Consultation Response from KC, Conservation & Design**2024/92136 Tower Works, Birkhouse Lane, Paddcok, Huddersfield, HD1 4SF****Erection of first and second floor extension, formation of improved access and refurbishments****Date Responded: 04.09.2024****Responding Officer: S Pickles****Responding Ref:**

Front Elevation South  
1 : 100

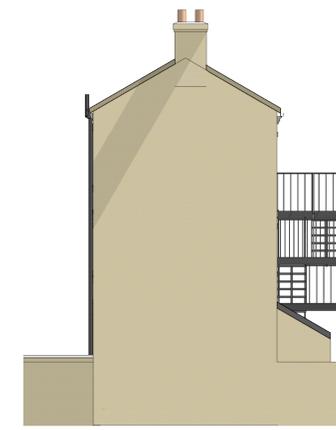
The proposals for the site are twofold, alterations to the existing building and the addition of a 2-storey side extension. The alterations to the building include the removal of the central ground floor doorway, removal of the roller shutters to the ground floor windows, removal of the existing windows and replacement with what appears to be 1 over 1 sashes and the removal of the chimney stacks. We welcome the removal of the roller shutters however we are concerned with the other alterations. The replacement windows see the loss of the historic fenestration detail, which does besit the character of the building. We consider that the windows to the front elevation should be reverted to the 8 over 8 configuration. We also consider that the chimney stacks should be retained as they do from a key part of the character and with the removal it would devoid the building of detail.

Regarding the proposed side extension. We consider the extension acceptable in principle, however, we are not convinced by the proposed material palette. We understand the rationale, however, we are not convinced by the proposed finish. It may be that a reduction of the amount of cladding would overcome the concern. For examples using natural stone for the main elevation up to the top of the first floor windows, then using cladding for the second floor.
